Manor Nursery, Angmering

Response to Comments made by Arun District Council dated 1 November 2018

Proposed Surface and Foul Water Drainage Layout

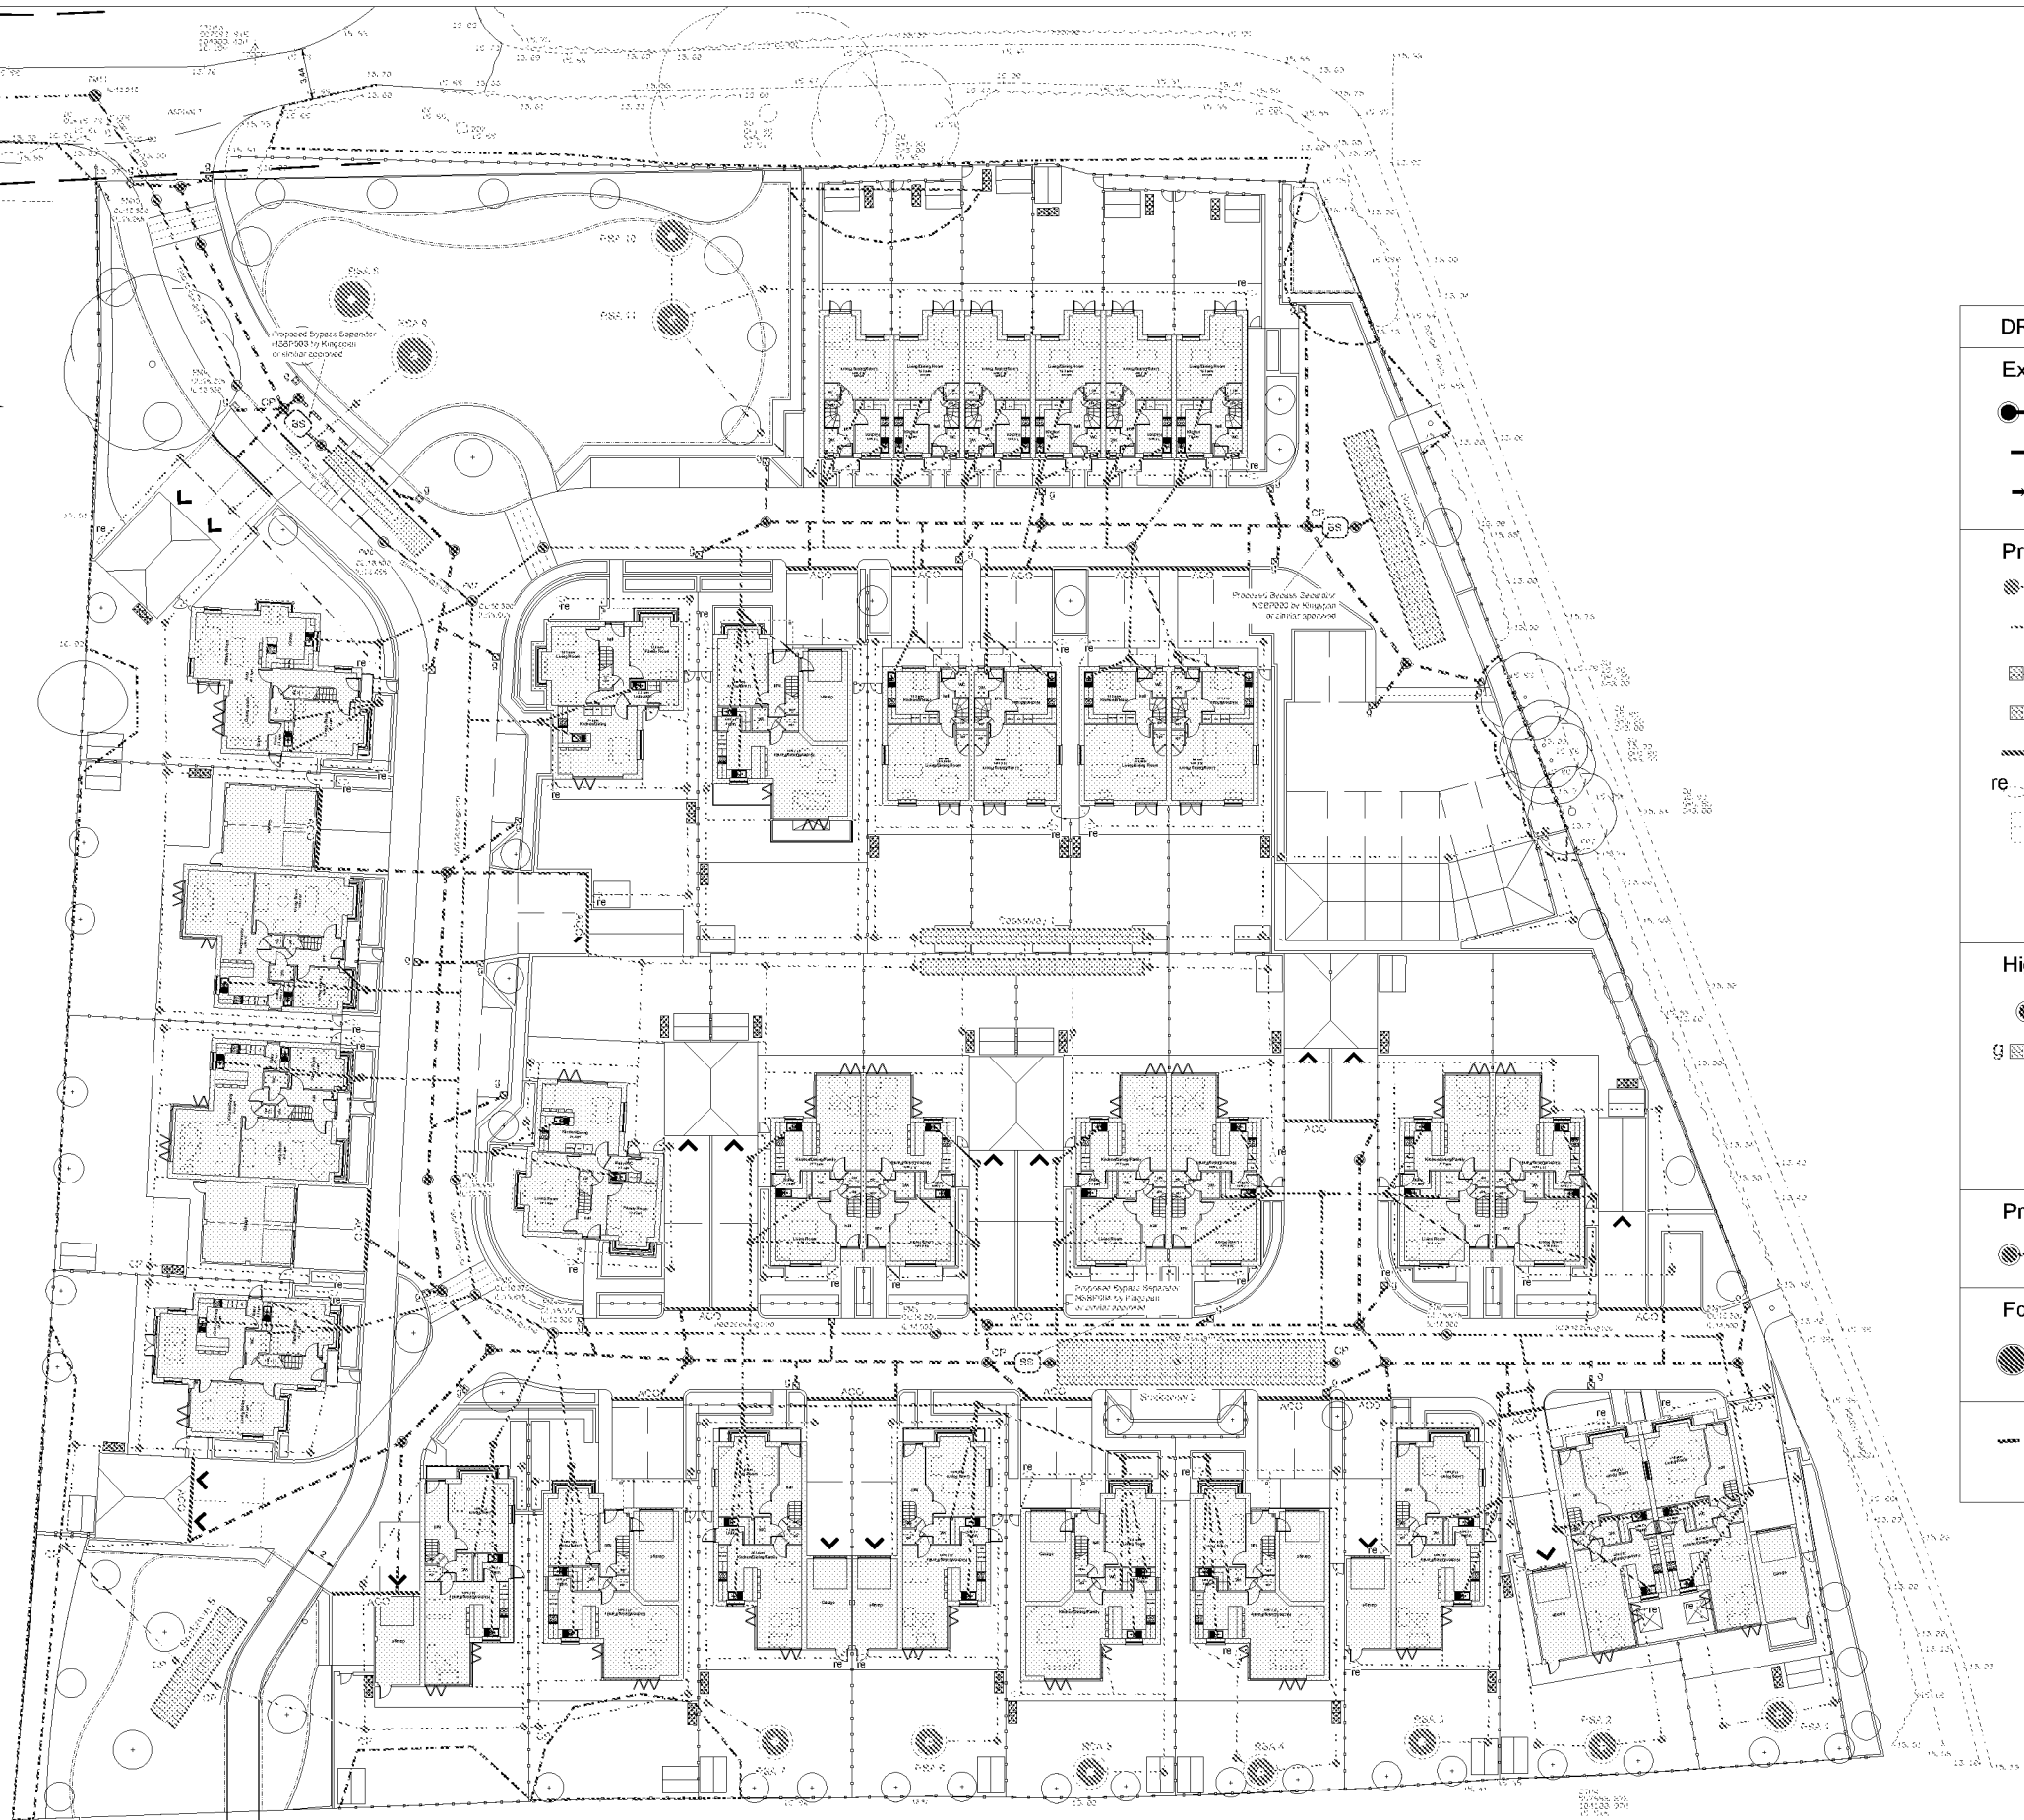
Arun District Council Comment / Query	Response from Applicant
I have reviewed what Sam Sykes has stated and that is fine, it is all in line with the supplied details. They are proposing to dispose of surface water by infiltration. As I have stated previously this is all very dependent on them finding the gravel layer, otherwise the area is quite impermeable and they may need to reconsider.	Site investigation for the development site immediately south of this site granted planning permission under reference A/167/14/PL confirmed the presence of permeable substrata. The FRA dated March 2015 which accompanied that application and remains in the public domain on the planning portal at Arun District Councils website includes reference to the site investigation and confirms the depth to the gravel layers to be typically within 2m of ground level. (Section 3.3.3) Subsequent soakage tests confirmed rates of $4 \times 10^{-3} \text{m/s}$ which is extremely high. The locality has been proven to be highly suitable for infiltration techniques.

2 Until detailed ground investigations and infiltration testing is completed it is not possible to definitively say that they will not discharge to a watercourse.	As Above. Infiltration rates are extremely high within the gravel. It is the intention of the applicant to accord with the drainage hierarchy requirements of the Non-Statutory Technical Standards for SuDS and discharge surface water to ground.
